Thomas FitzGerald - Online Submission from Greg Burgis of Friends of Terranora (object)

RE: Submission to 09-0166 Residential Subdivision 'Area E' Fraser Dr Terranora NSW

METRICON (QLD) PTY LTD
ALTITUDE 1 - FRASER DRV. TERRANORA
EARTHWORKS LAYOUT
SHEET 1 OF 5

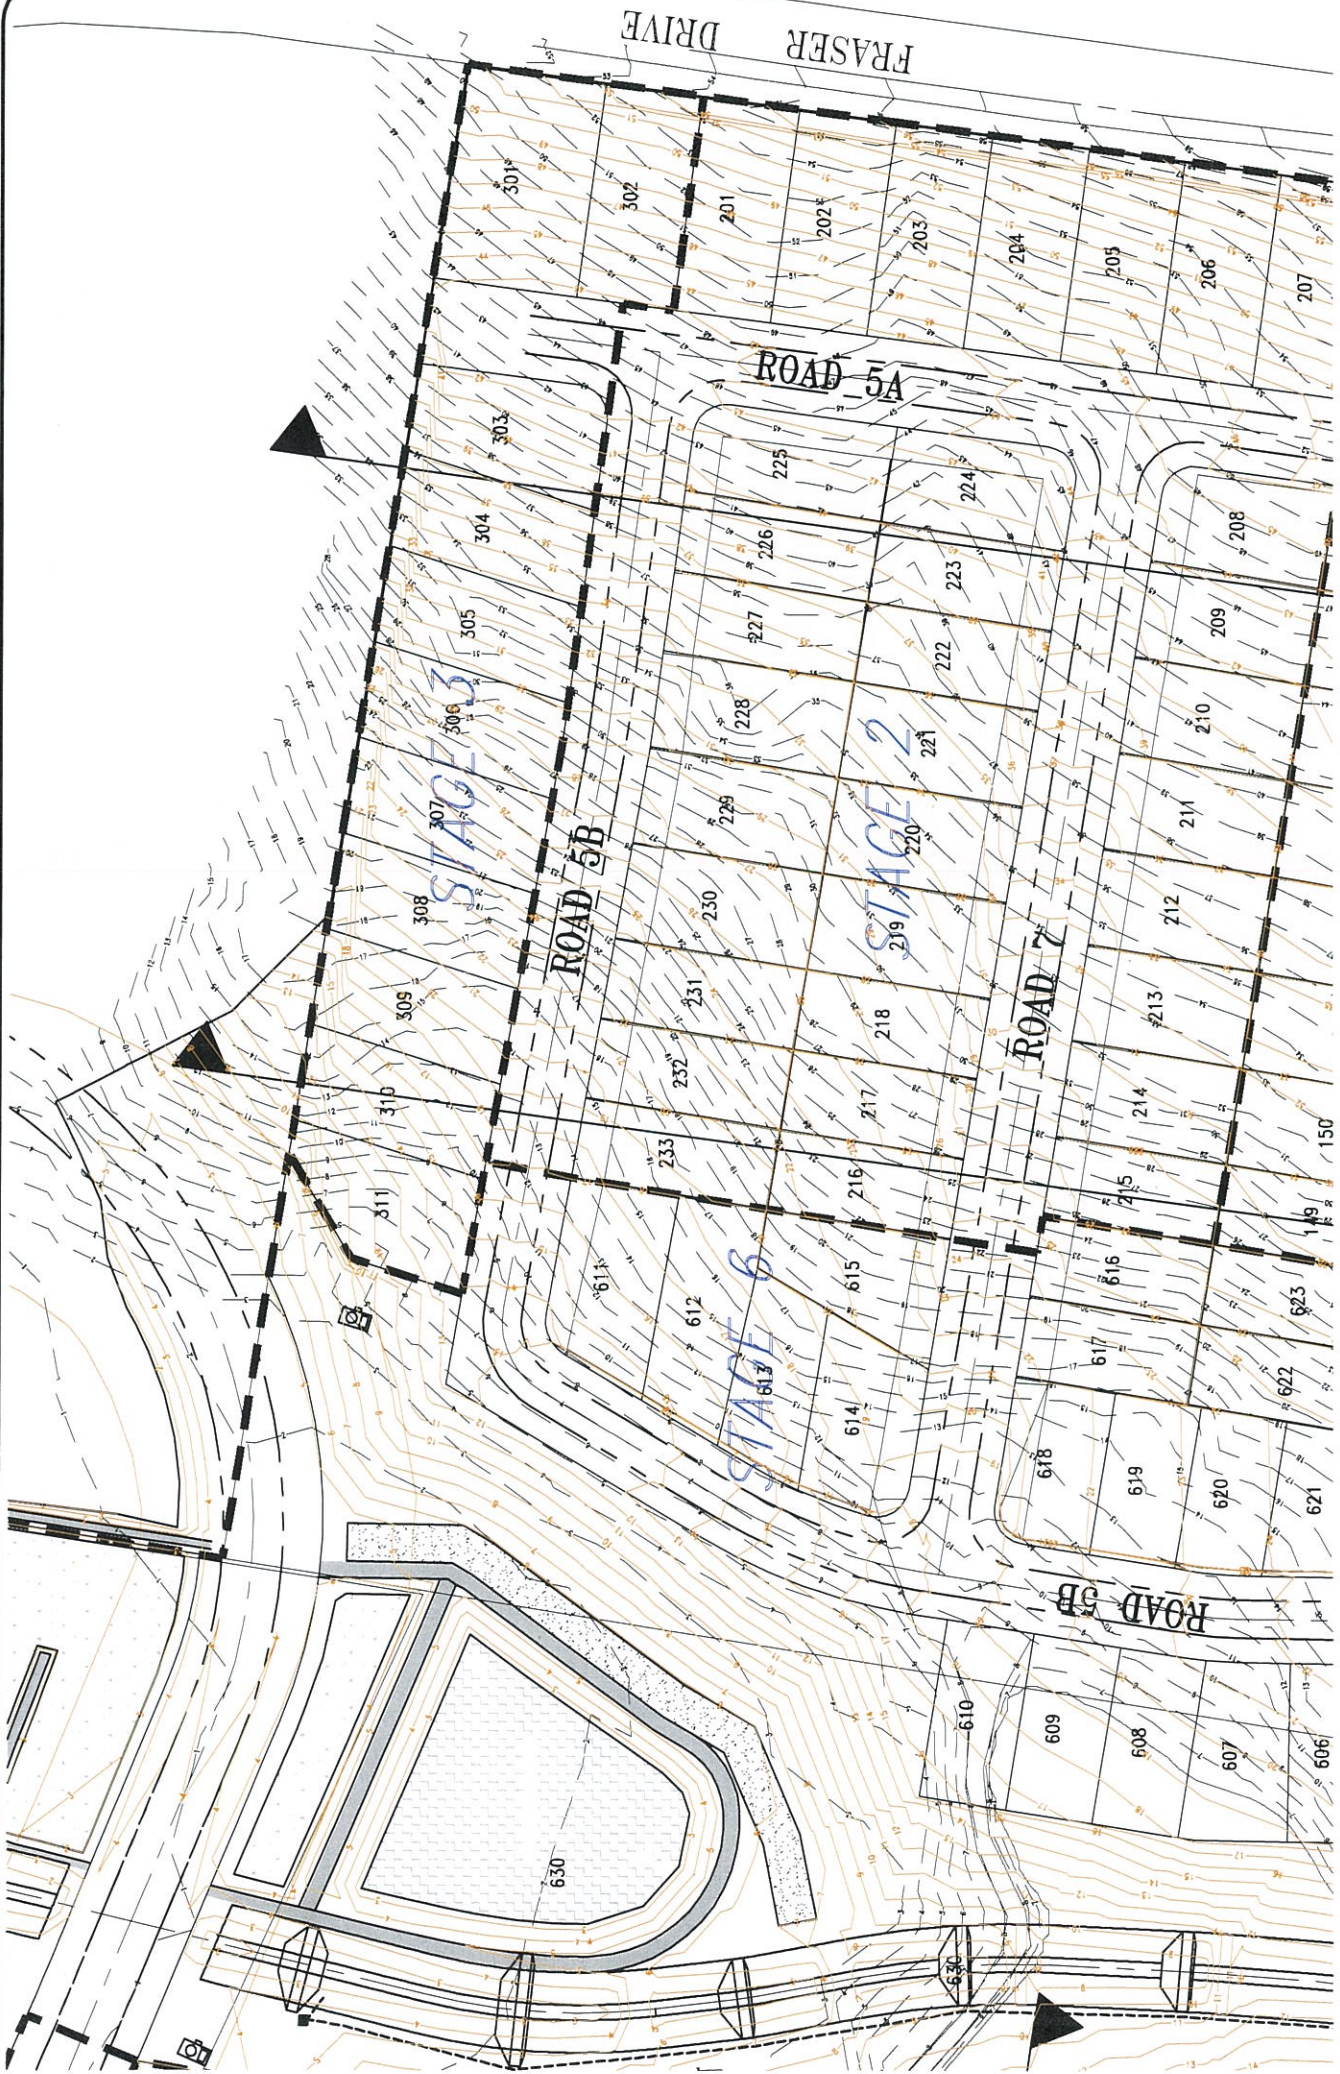
The DG requires the developer [at 2.5] to demonstrate minimum cut and fill /and slope sensitive building design. This has not been done. We object to the use of cut and fill homesites in this high rainfall area and because of critical stated risks of cutting into weak soil stratum and thereby creating instability. Retain natural ground. Only the top 100mm of red soil is fertile. This is typically site dressed [bulldozed away and even sold for profit] by developers causing purchasers to endlessly use nitrogen fertilisers which ruin lake ecology.

On the proposed Fraser Drive subdivision of 317 lots, the average 800m² lot size has not been utilised but should be to minimise cut and fill as per Council's code. Instead, most lots are proposed to be on seriously deep cut and fill sites. Such rock retaining walls in Terranora are favourite hideouts for snakes and rodents. Most proposed streets go directly up steep hillsides rather than follow contours along the hillsides as they should. [Solar orientation should not be the priority here]. All sites must be natural ground as happened very successfully in Terranora Village in the 1990's. Project slab on ground house designs are inappropriate here. Force innovative designs on natural ground. The consultant states the land has serious seepage issues and is especially slip prone near the interface of red krasnozem and clay- this occurs throughout 3 sides of the property. We object to disturbing soils on home sites. Adopt large lots.

BROADWATER PARKWAY
LAYOUT

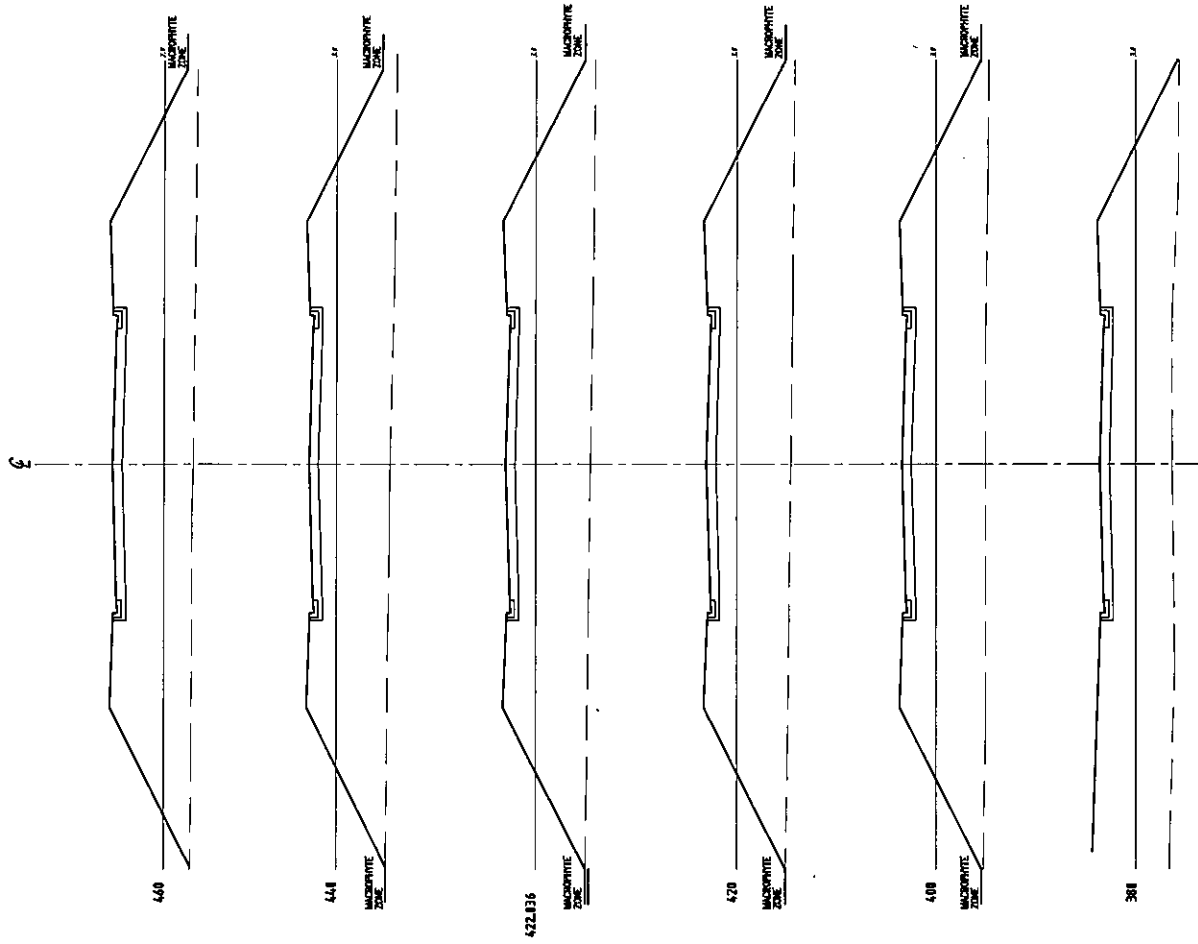
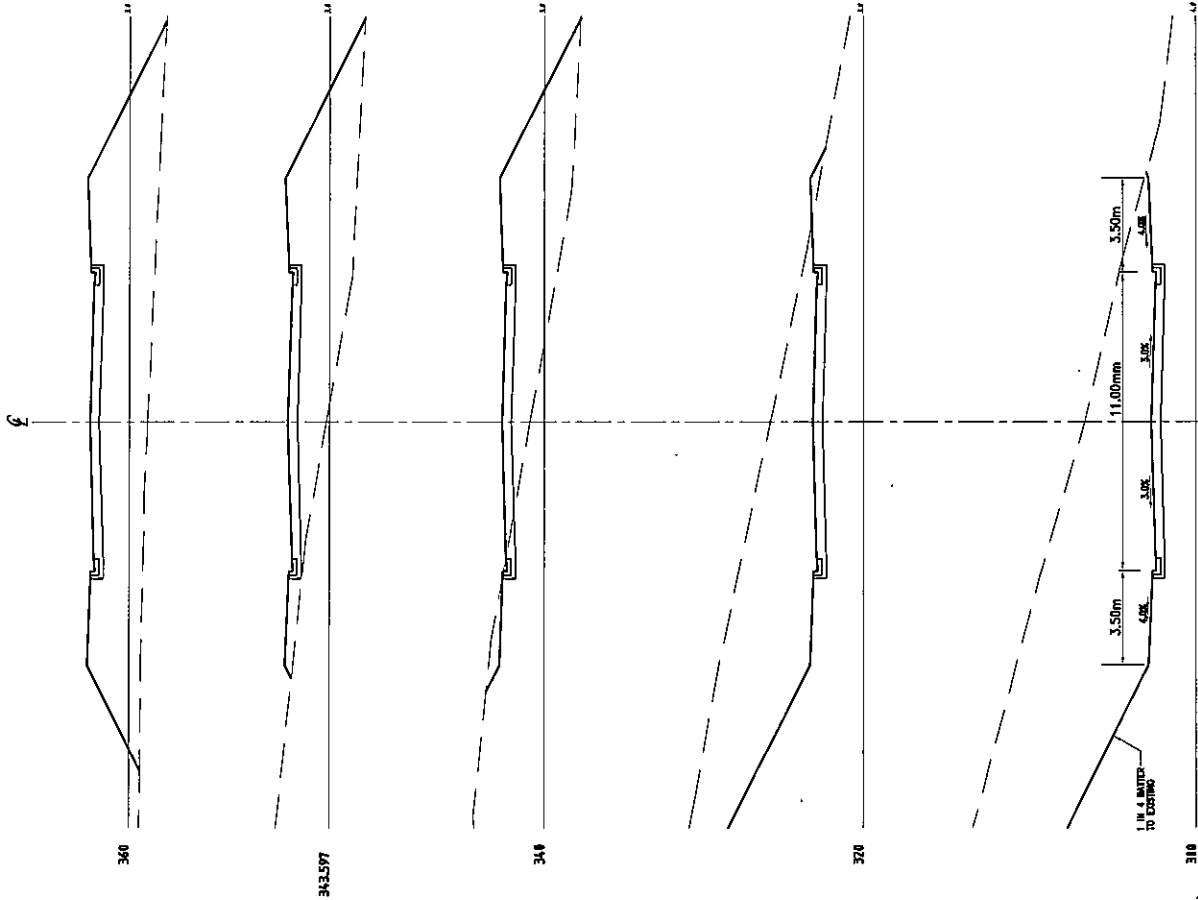
- + The LES locations of this road were deliberately vague but were within the Residential Zone. No road should be within SEPP 14 wetland. Remnant high value rainforest patches along the edge of the

wetland and within the residential zone must not be destroyed. The road location must be up slope from these trees for conservation purposes and to improve the appeal of the drive.
